Re: Planning application 2024/60/92031/E

Outline application for erection of residential development, adoptable road and public open space at Headlands Works, Headlands Road, Liversedge, WF15 7NT - RECONSULTATION

The Coal Authority response: FURTHER INFORMATION REQUIRED

**MWA DRAWING NO. RSHR-MWA-XX-XX-DR-A-  
0003\_PROPOSED SITE LAYOUT (REV P8) SHOWING MINE  
SHAFT POSITIONS**

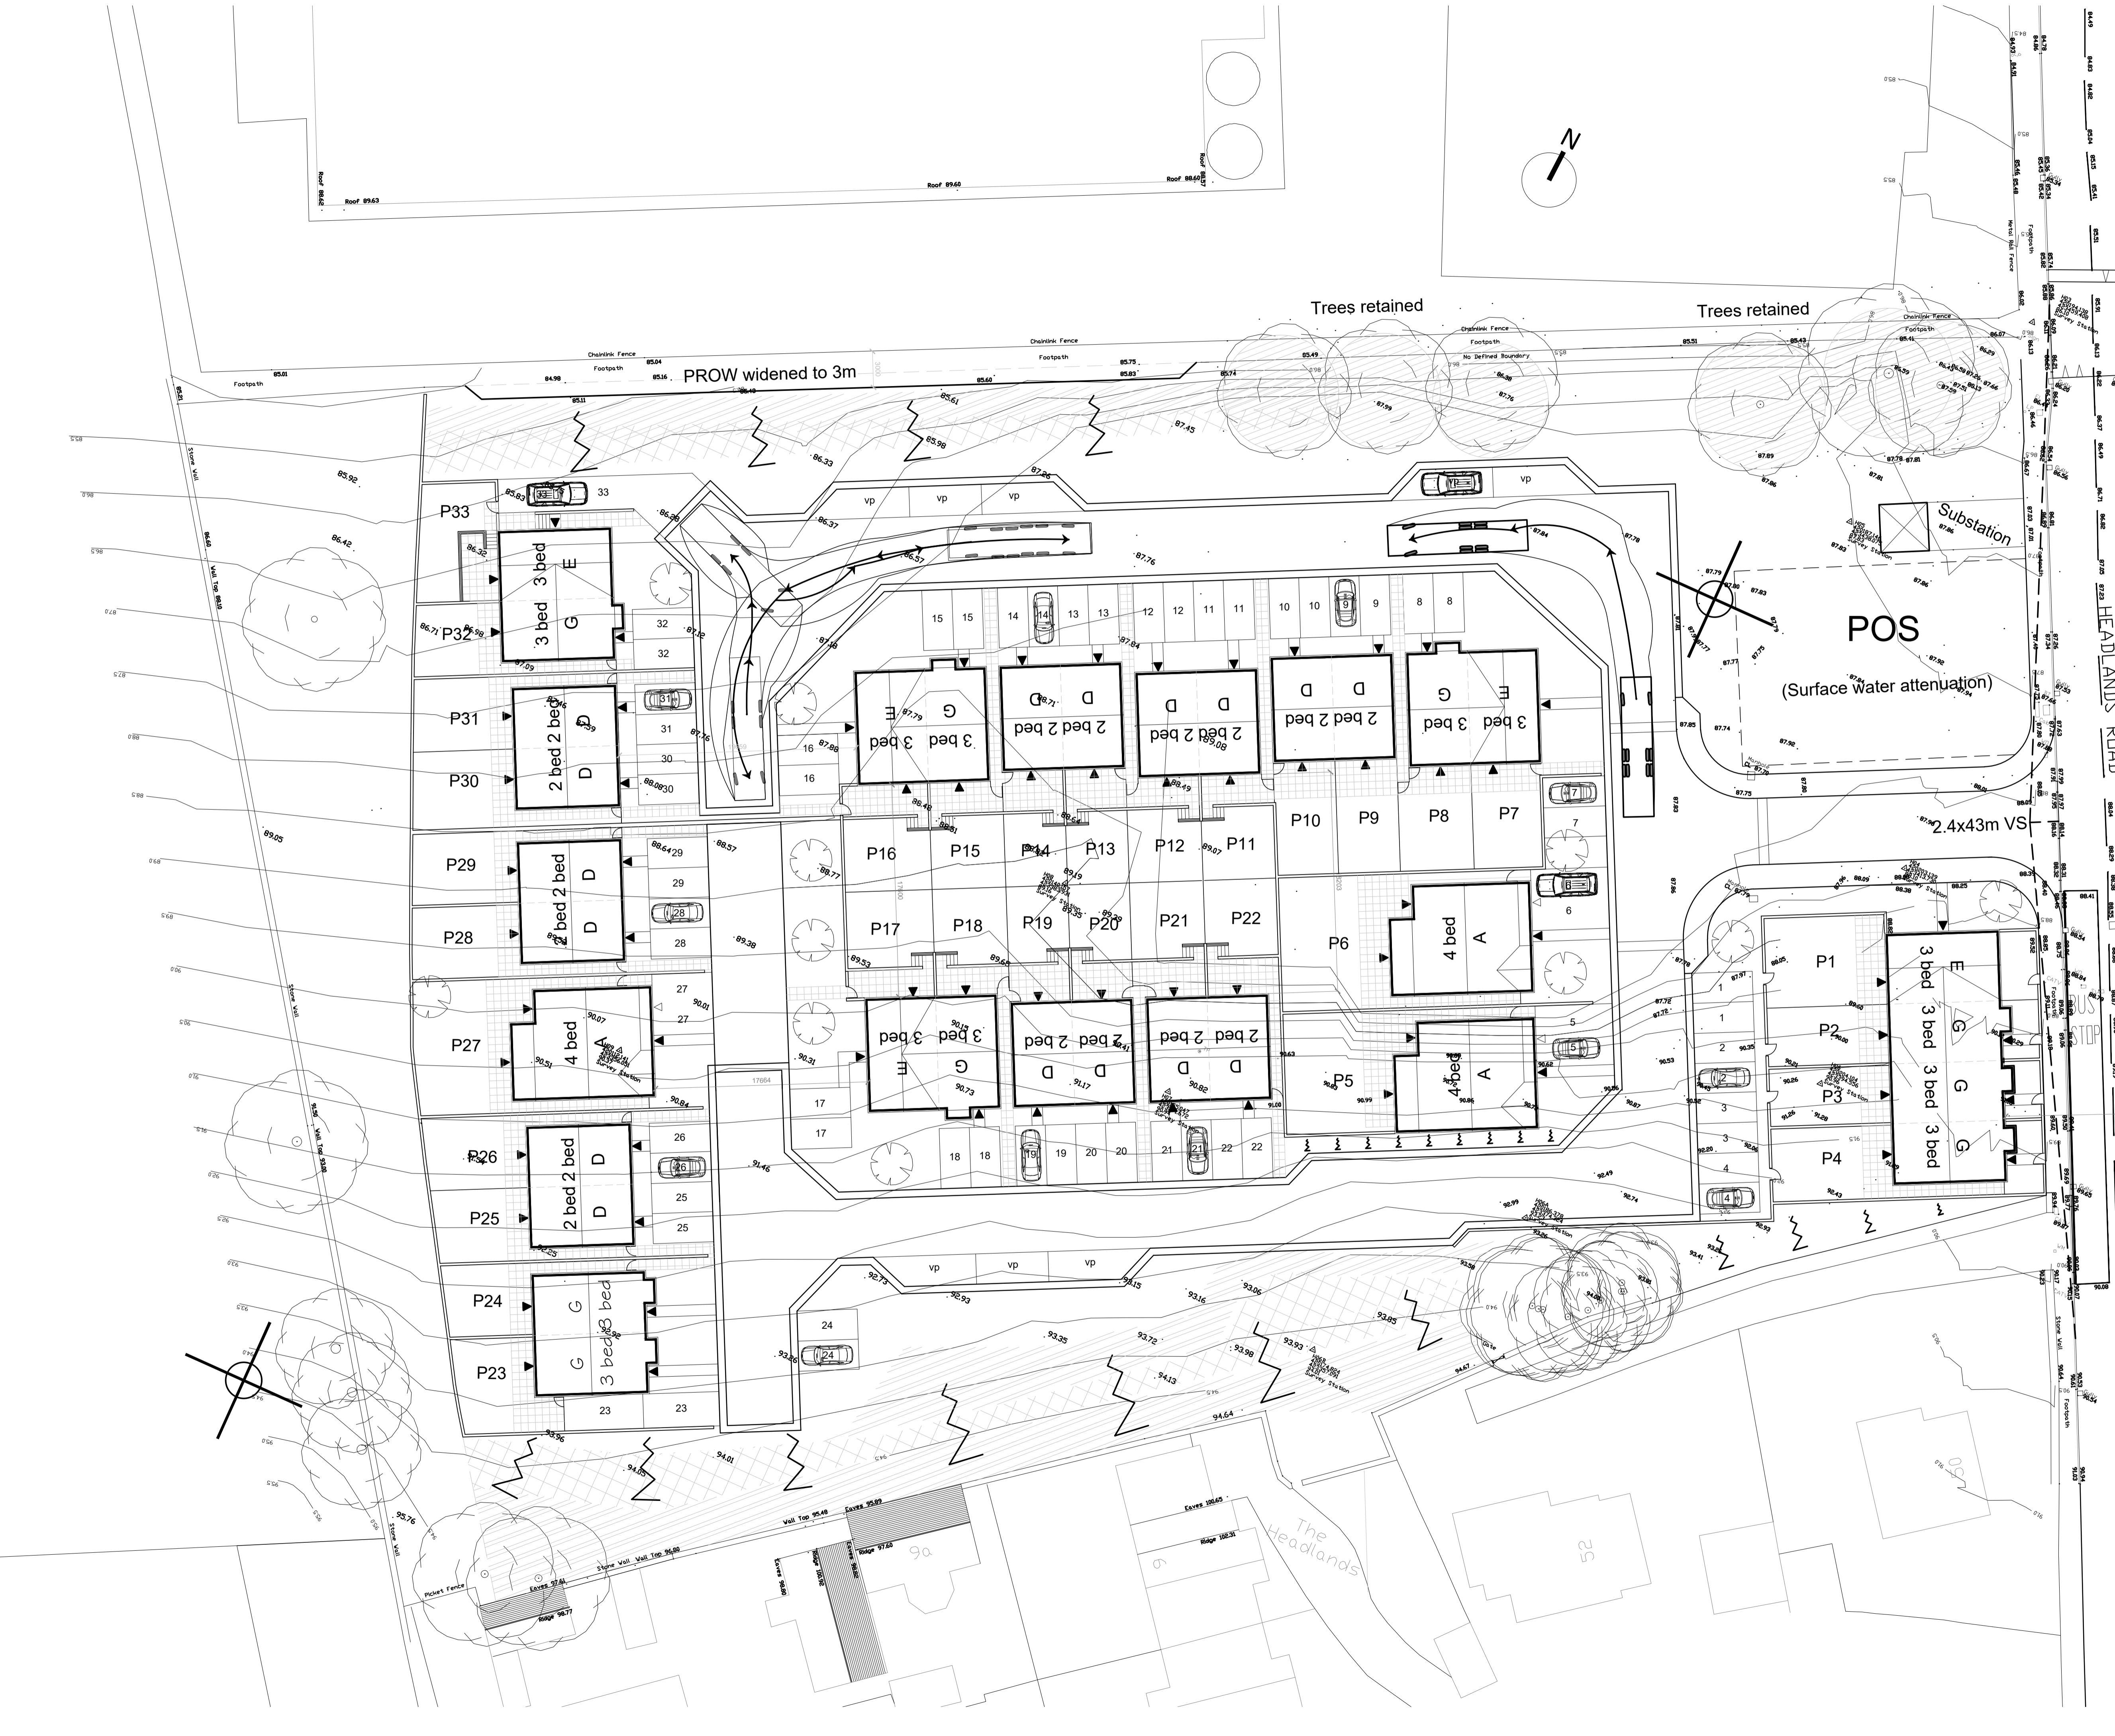
Despite the above, we understand that since we initially provided comment, the LPA has received an amended Proposed Site Layout (Drawing no. RSHR MWA XX XX DR A 0003 P11), which now includes the location of the recorded mine shafts. We note that buildings have been moved further away from the on-site shaft, although this mine entry could be sited beneath the proposed surface water attenuation feature.

Whilst we welcome the apparent efforts made to reposition buildings away from the shafts, we must point out that our positions for these features are best plot positions. Due to potential plotting inaccuracies, the actual positions of the shafts could depart/deviate from their plotted positions by several metres (8m in the case of on-site shaft 420423-021 and 10m for off-site shaft 420423-026). The potential zones of influence (instability) associated with the shafts would then extend beyond these departure radii.

- **A further Proposed Site Layout drawing should be submitted showing the plotted positions of the recorded mine shafts, their allotted departures and the extent of their associated zones of influence. As one of the factors that determines the size of zones of influence is the depth of superficial materials above rockhead, some limited initial intrusive investigations to obtain this data may be required should relevant ground data to assist in these calculations not presently be available.**
- **Due to its potential departure of 8m, there exists the potential for the on-site mine shaft to be present beneath the proposed surface water attenuation**

feature. For clarity and the avoidance of doubt, the applicant should provide confirmation that their technical consultant has considered the potential stability and public safety risks posed by the interaction between the shaft and the attenuation feature and considers these to be acceptable. You may consider it prudent to seek confirmation from the applicant that the treatment of the shaft in accordance with authoritative UK guidance (CIRIA C758D) will not compromise the drainage function of the attenuation feature.
